Permit Number: 080460

has permission to Interior Tenant Fit-up.

AT 125 PRESUMPCOT ST

| Proposed Use: Commercial - Pediatric Development Center/ Interior Tenant Fit-up. | Proposed Project Description: Interior Tenant Fit-up. |

BY:	JJO
NO. REMARKS:	ISSUED FOR PERMITTING
DATE:	05-30-13
CODE:	IBC 2009
TOWN:	PORTLAND
DATE:	05-30-13
SCALE:	AS NOTED
DRAWN:	JJO
TITLE:	Schedules & Wall Types
FILE:	051-010-10
SHEET:	A1-07

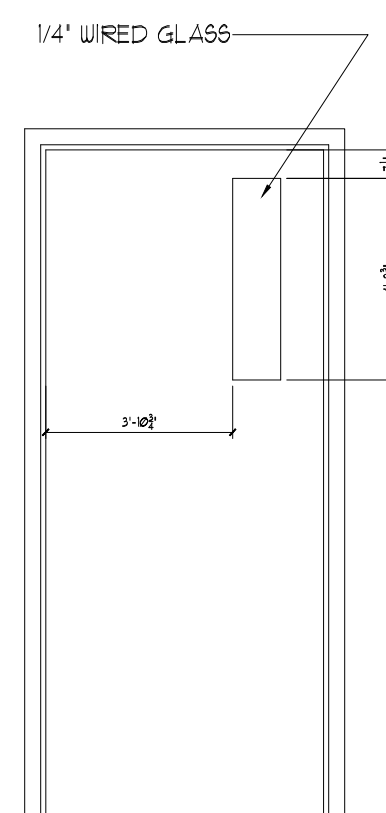
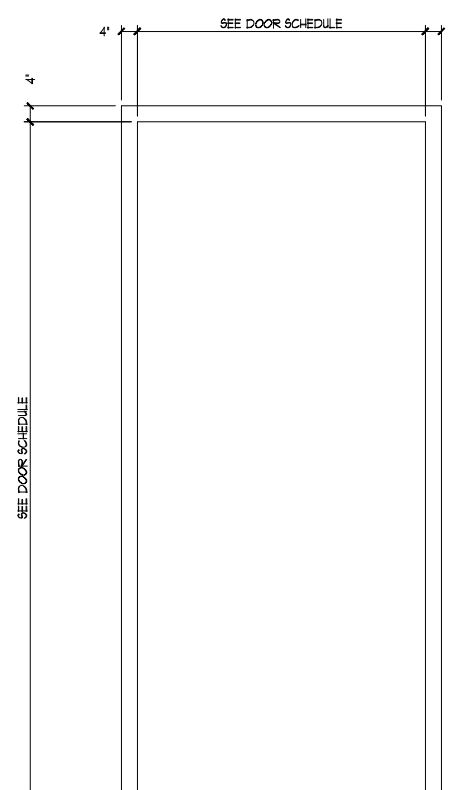
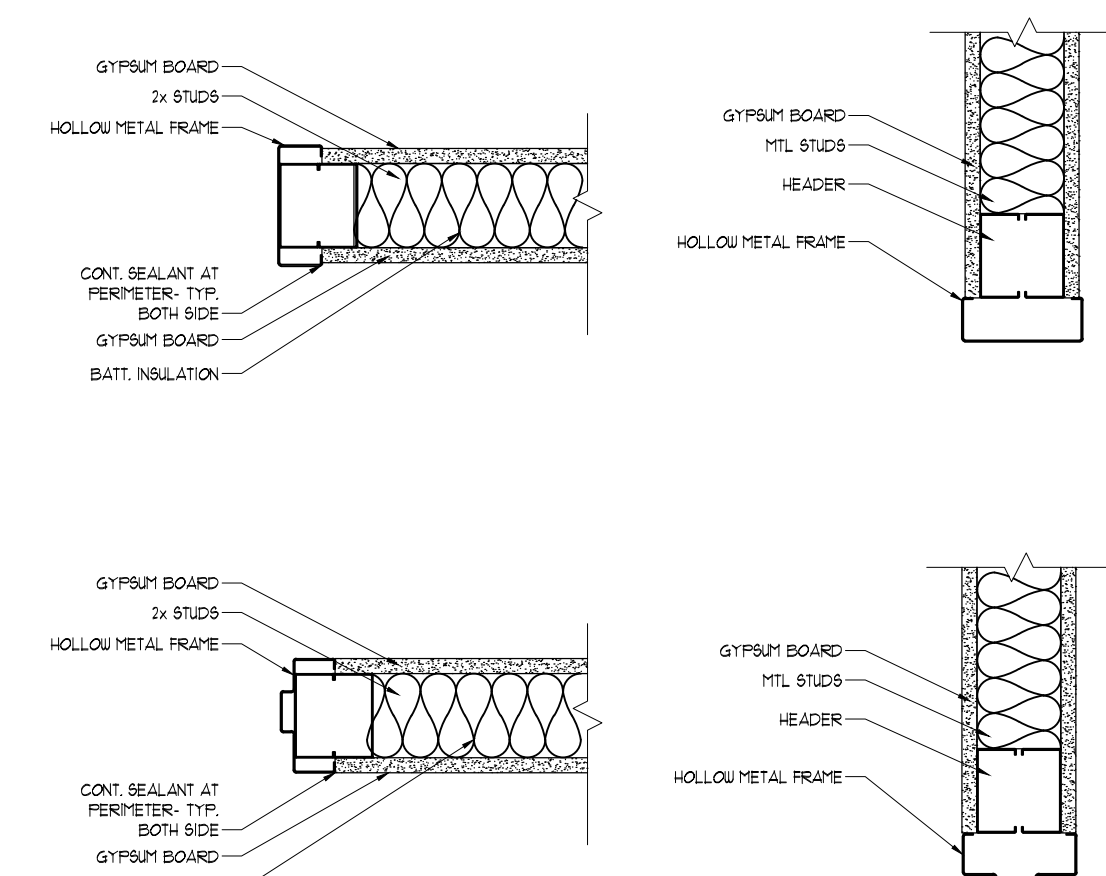
Comments:
6/2/2008-jmb: Left voicemail with Earle R. For details on the demising wall and adjacent use, suite #, bathroom count which looks ok based on actual number of staff and clients.

| 6/3/2008-jmb: Earle called back to confirm it is a demising wall, he thinks they are trying to emailed Mark G. At Cubellis for revised wall type detail. Bathroom count is ok | Phone: | Permit Type: Alterations - COMM |

| 6/5/2008-jmb: Received revision of fire rated wall type C from architect, ok to issue | | |
